Heritage Council

Contact: Lucy Moore
Telephone: (02) 9873 8535
Email: lucy.moore@heritage.nsw.gov.au
File: 13/07547
Job ID No: A1433108, A1435148, A1437026
Your Ref: 11/18834

**RE: Exhibition of Environmental Impact Statement for
Wallarah 2 Coal Project (SSD 4974)**

Figure 6: Location of historic heritage items within and in proximity to the Project Boundary. For identification of the numerals and letters refer to Table 3.

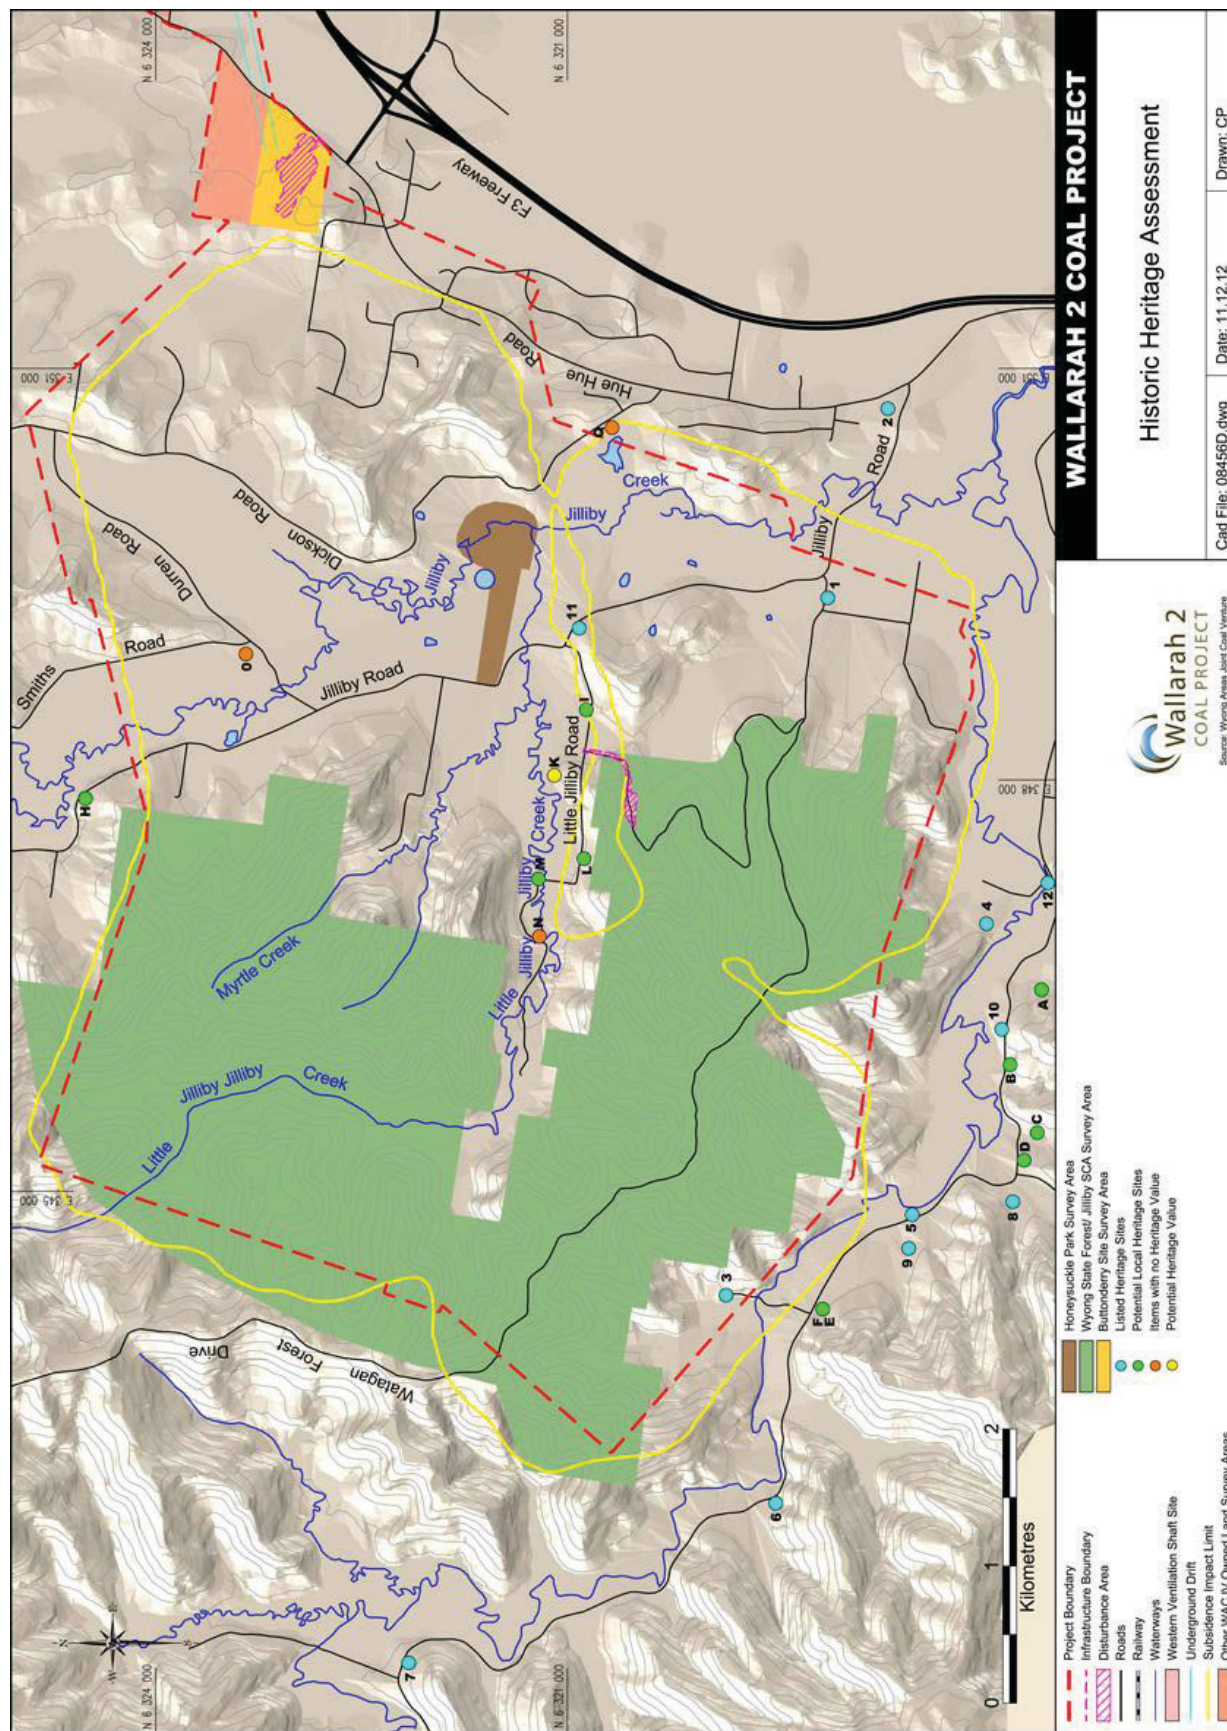
The EIS identifies that 13 known heritage items and 19 potential heritage items are located within or adjacent to the project site. Of those identified, no sites will be directly impacted by the project but four known and one potential heritage site will be within the Subsidence Impact Limit and may be adversely affected by subsidence or increased flooding.

It is noted that in identifying the known and potential heritage items, the EIS consulted statutory and non-statutory heritage lists including the State Heritage Register and Wyong Council's Local Environmental Plan (1991). Wyong Council is currently preparing a new LEP and the Draft LEP 2012 is available on council's website (<http://www.wyong.nsw.gov.au/building-and-development/local-environmental-plan/draft-wyong-lep-dcp-ss-2012/>). It is recommended that Wyong Council be consulted to ascertain whether any new heritage items have been identified and included in the draft plan. If so, these items should be considered in the EIS.

Upon reviewing numbers alone, the LEP 1991 contains 97 heritage items while the Draft LEP 2012 contains 159 items—an increase of some 52 identified items.

A characteristic of Wyong Council's LEP 1991 and Draft LEP 2012 is that no archaeological heritage sites have been identified. It is recommended that the applicant undertake a thorough investigation of potential archaeological sites and the results incorporated into the EIS.
